Application No: EP/124/20/HH
Site Address: Little Dormers 23 Upper Drive East Preston BN16 1QN
Description of works: New bay and porch skirt roof to the front elevation, and roof linked detached double garage.

Thank you for your internet representation made on 16th November 2020 which has been recorded as an objection with the comments as follows:

Garage Plans and Elevations -
Proposed

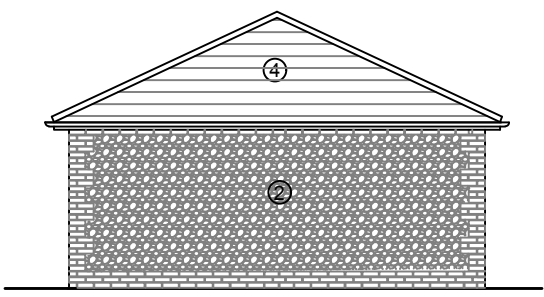
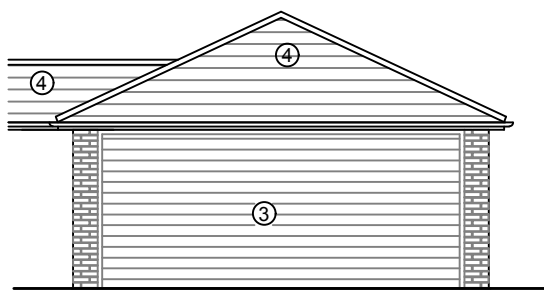
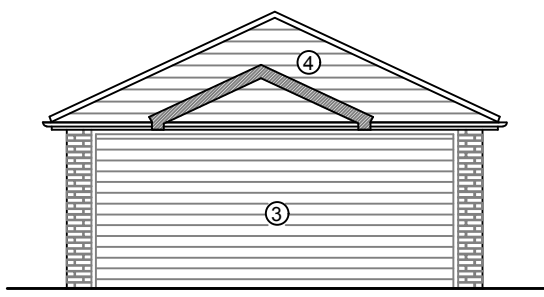
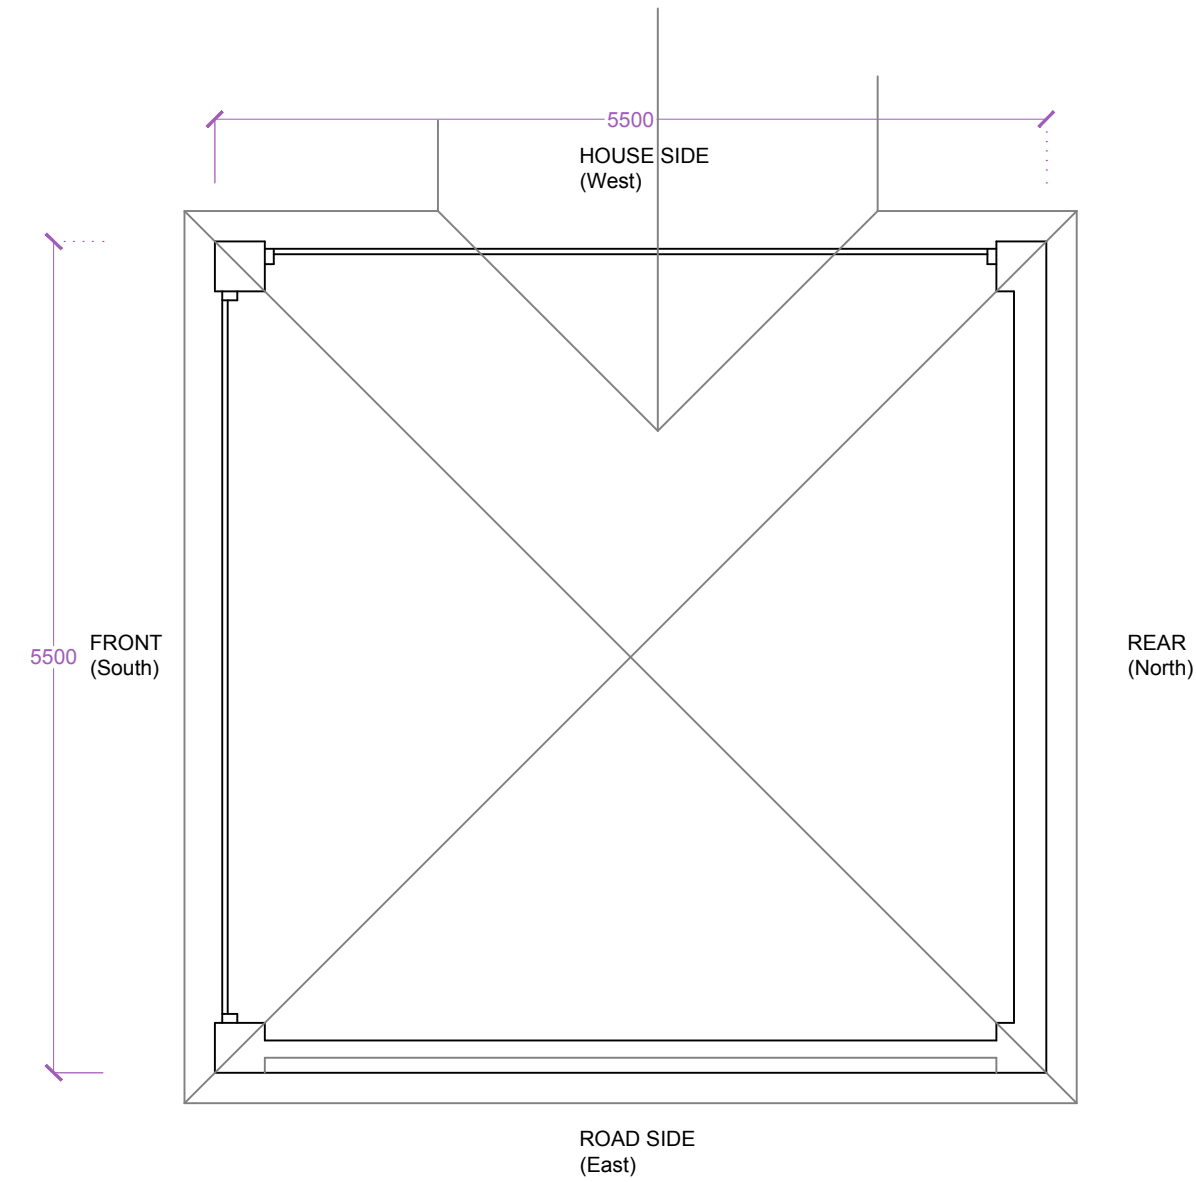
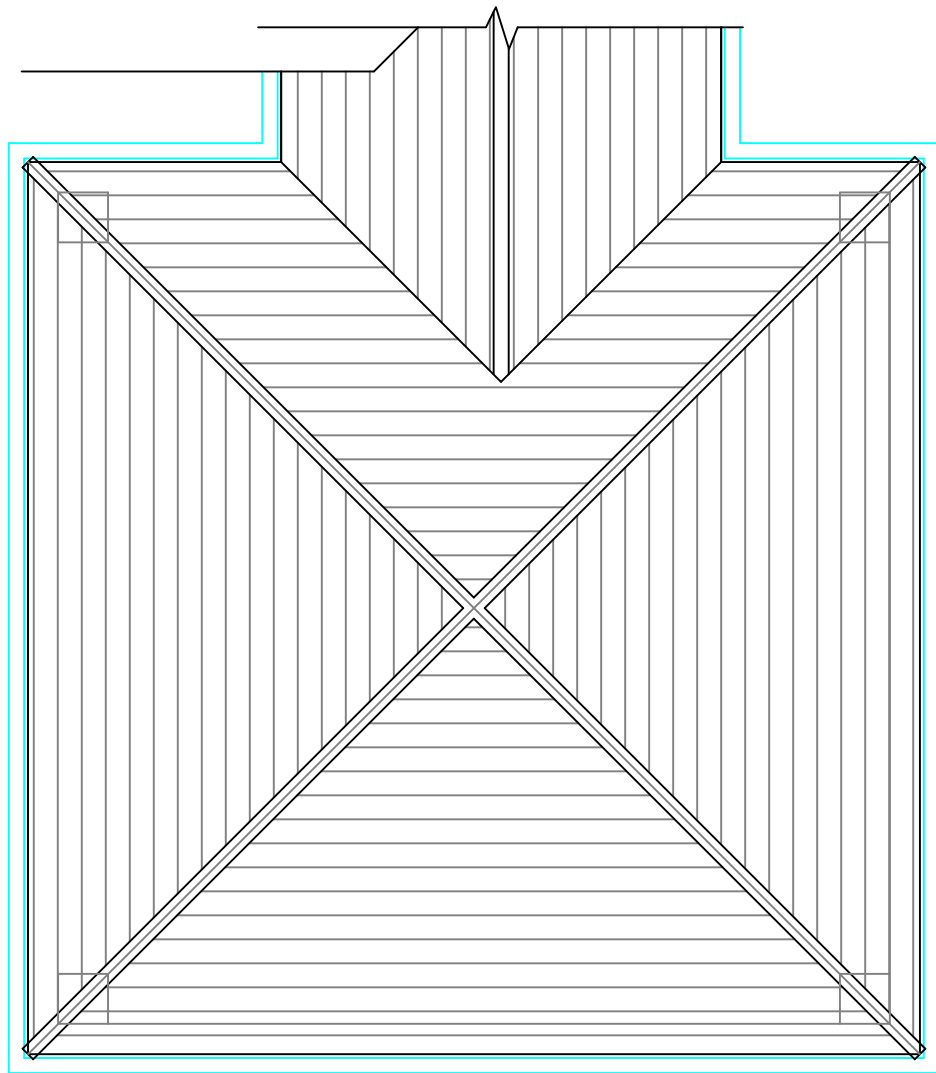
With reference to the above planning application we wish to object strongly against the proposed detached double garage at 23 Upper Drive East Preston. We feel this will infringe on the neighbours at number 25 and 27 Upper Drive and will take away their light and would look out of character and unsightly for the whole area.
